TO: Robert Heiser and Saige Cox / Studio Southwest Architects
FROM: Sergio Lozoya, Current Planner
City of Albuquerque Planning Department
TEL: (505) 924-3349
RE: AA PR-2021-005746 – SI-2022-00947 5800/5900 Jefferson St. NE

I am the Staff Planner reviewing your application for project # PR-2021-005746, an Administrative Amendment at 5800/5900 Jefferson St. NE – XRANM, for parking and site improvements.

AS113

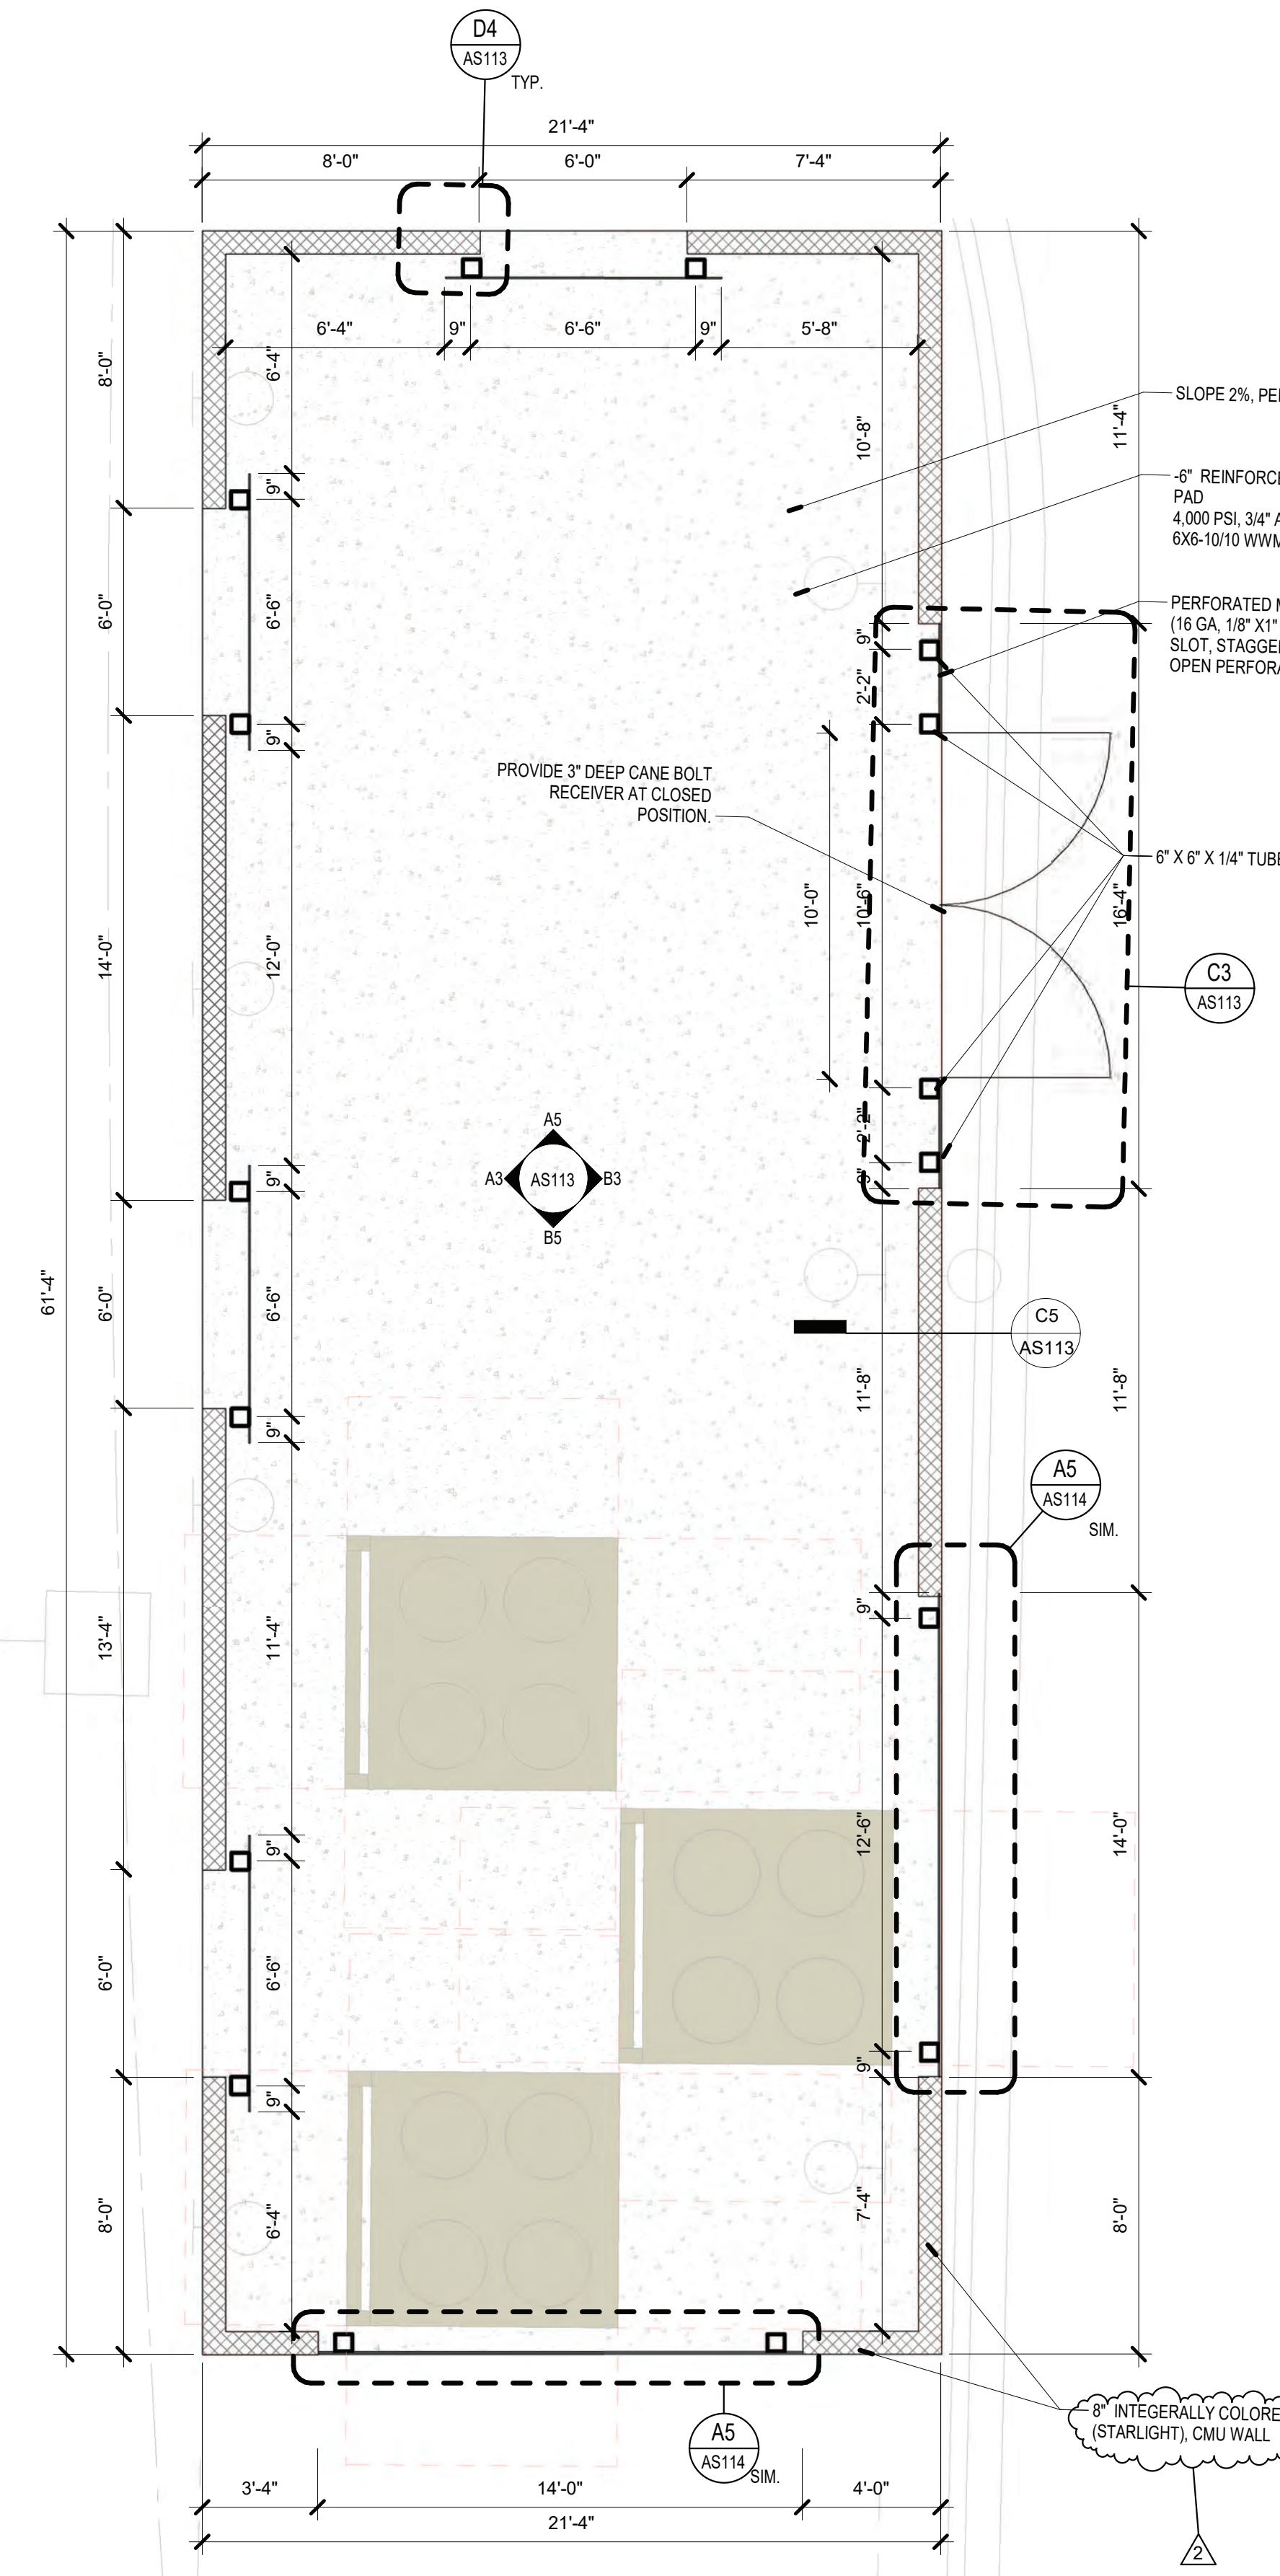
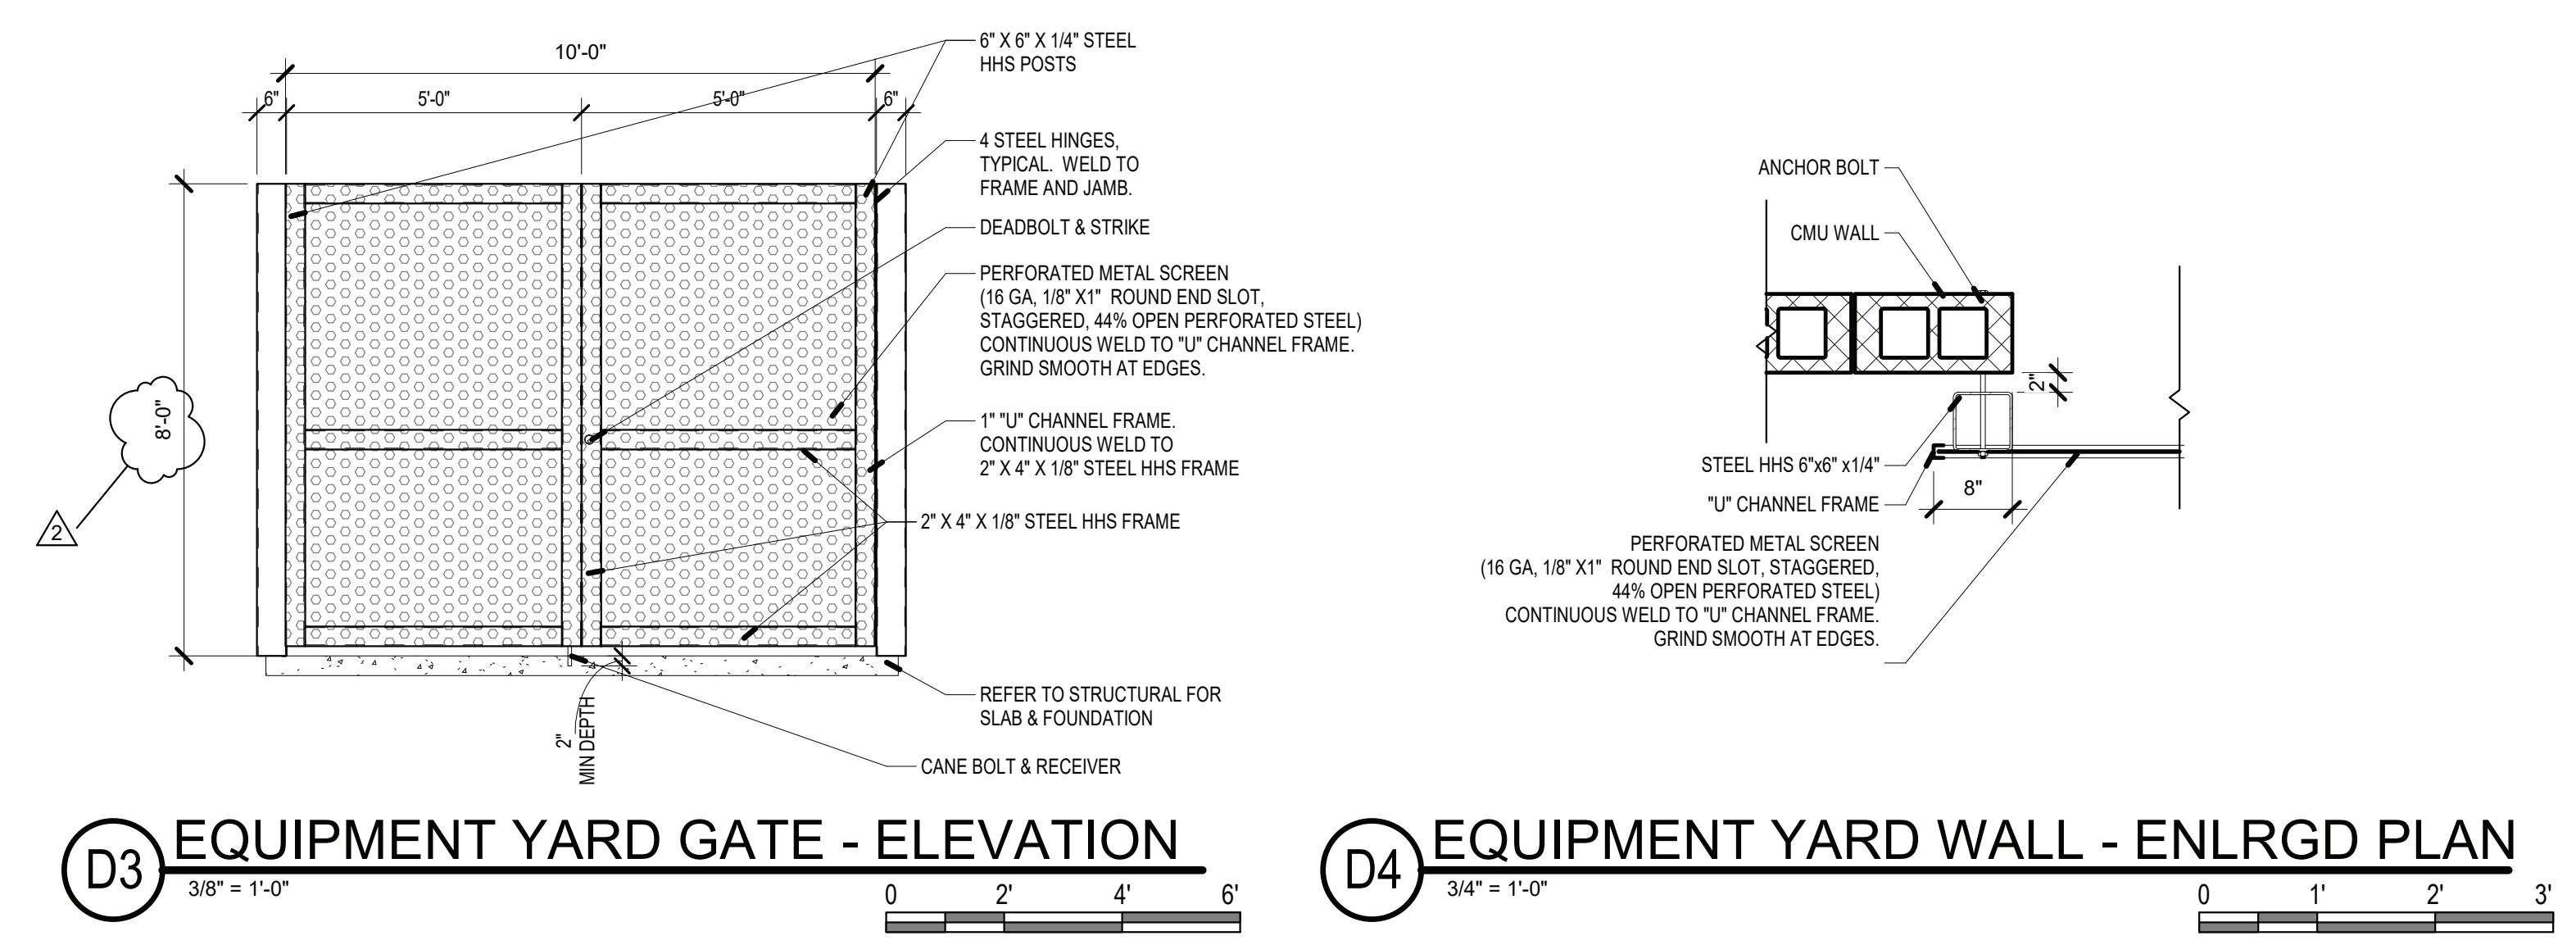
The change in height for the equipment yard wall from 12'-6" to 8'-6" exceeds the allowable 6" change pursuant to the provision shown above (IDO Table 6-4-4 Allowable Minor Amendments).

If the change to wall height is desired, this application will have to be processed as a Major Amendment, and would return to the original approving body (DRB). This application can proceed as a Minor Amendment if the wall height remains within the allowable Minor Amendment thresholds.
